12 August 2015

Our Reference: SYD14/00350/03 (A9884862)
DP&E Ref: SSD 6454

**CONCEPT PROPOSAL AND STAGE 1 DEVELOPMENT FOR SCECGS REDLANDS SCHOOL
272 MILITARY ROAD, CREMORNE**

Scale : A1 AS SHOWN	Drawn AS	Authorised
Job No 141531	Drawing No SKC240	Revision P1
Plot File Created: Oct 09, 2015 - 2:01pm

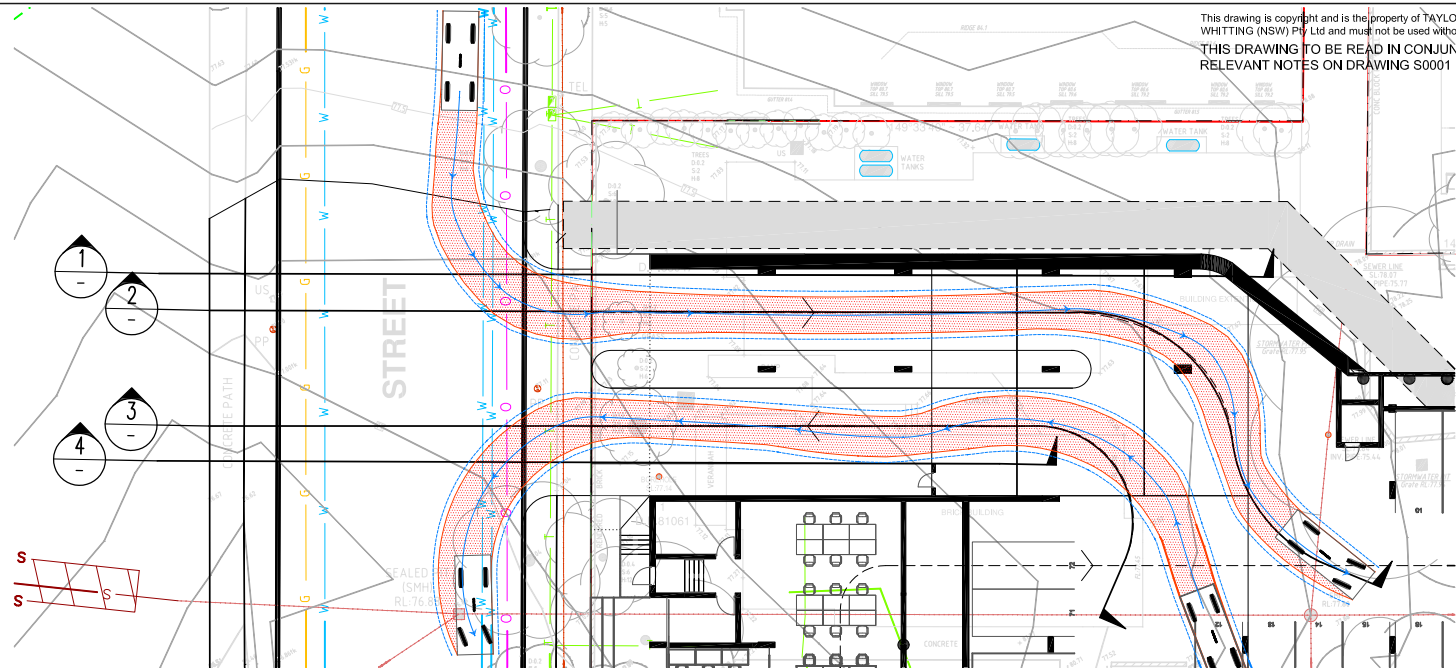
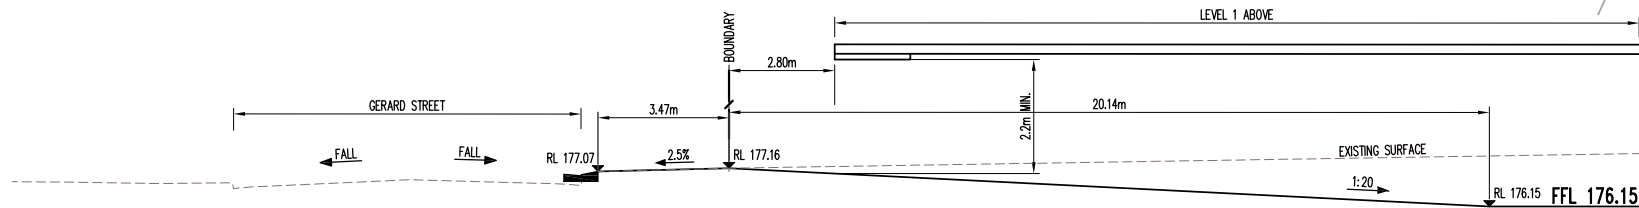
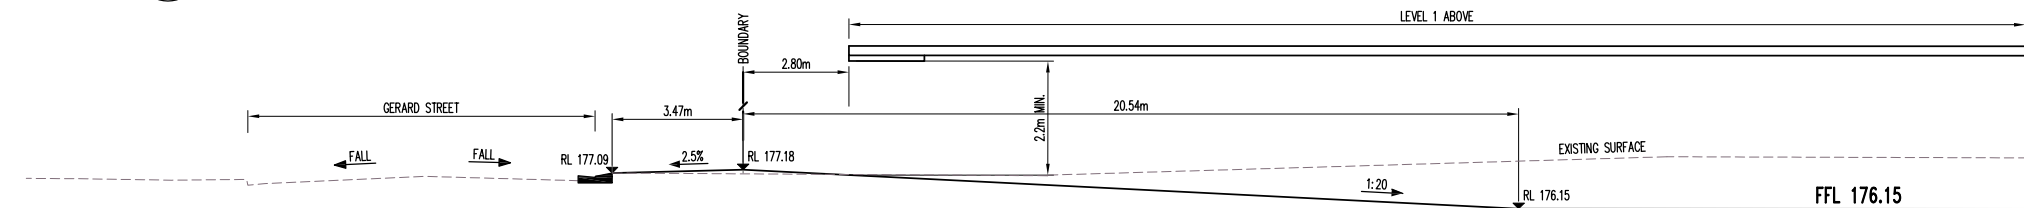
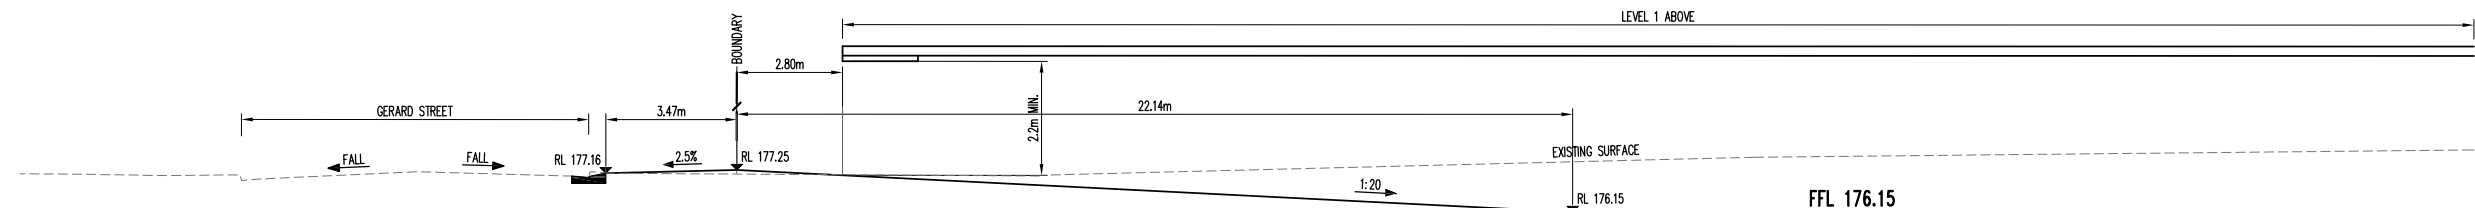
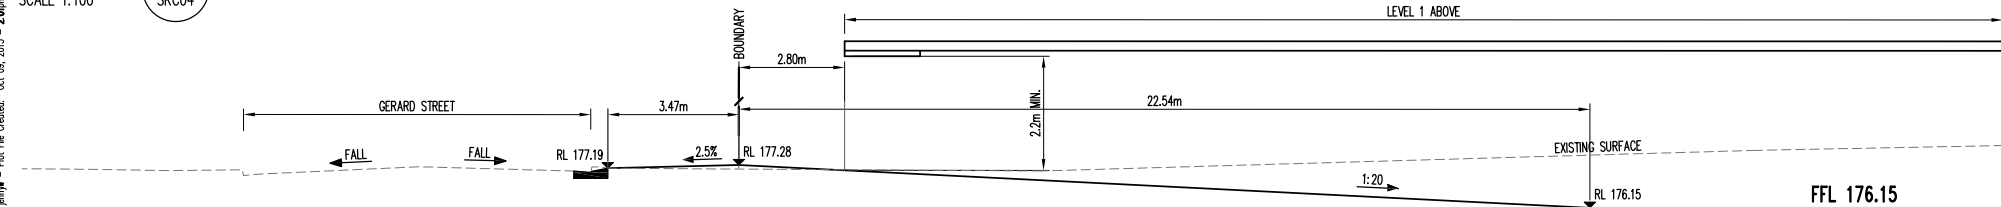
8. The swept path of the longest vehicle (including garbage trucks) entering and exiting the subject site, as well as manoeuvrability through the site, shall be in accordance with AUSTROADS. In this regard, a plan shall be submitted to Council for approval, which shows that the proposed development complies with this requirement.
